Re: Special Use Permit

Letter of Intent

Add PCD File No. AL194

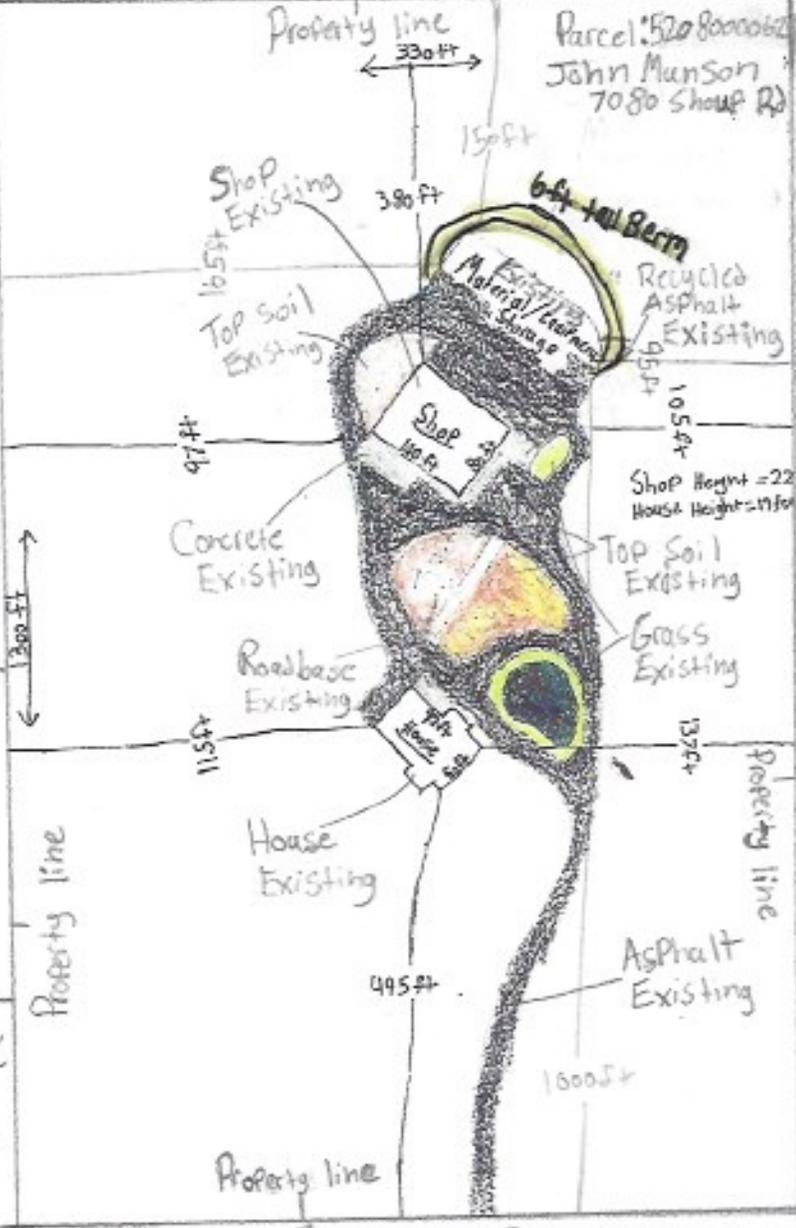
Provide screening for outdoor material and equipment storage area per Land Development Code Chapter 6 Section 6.2.2(G)(1)(f): Provide any combination of berms, shrubs, trees, fences, or walls which will provide at maturity, a minimum of 6 foot high, 100% opaque screening for the outside storage area. These should be shown on this plan for next submittal.

Provide dimension from the edges of the outdoor storage area to the property lines.

Show and identify the entire property line.

Identify the adjacent property owners (address, owner, parcel, etc.)

Show Shoup Road.

Identify the surface types and what is proposed or existing.

Identify if the structures are proposed or existing.
